Our Ref: JAH/SH

5th March 2020

re. Town & Country Planning Act 1990 (as amended)
Application ref: P/117/19/PL
36 East Front Road, Pagham – proposed replacement dwelling

PROPOSED STREET
SCENE & BEACH
SCENE

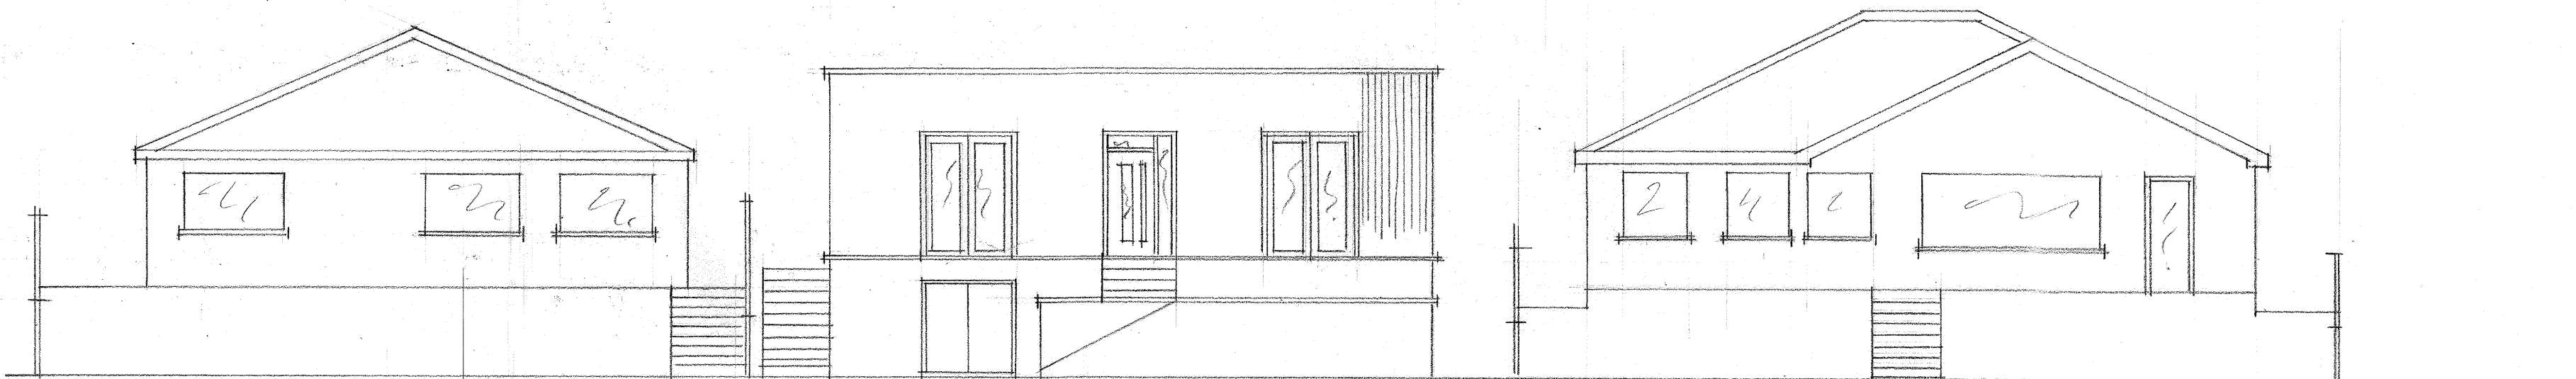
I also now note that EA has recommended that FFL within the building should be constructed at no lower than 5.53 AOD, which is the same figure that is defined within the Applicant's Flood Risk Assessment. However, there is no reference within the Applicant's Design & Access Statement or within the Beach Scene Elevation and Street Scene Elevation Drawings to confirm that the proposed bungalow has been drawn to reflect the FFL. In the circumstances I would urge the District Council to request this confirmation from the Applicant or his agent.
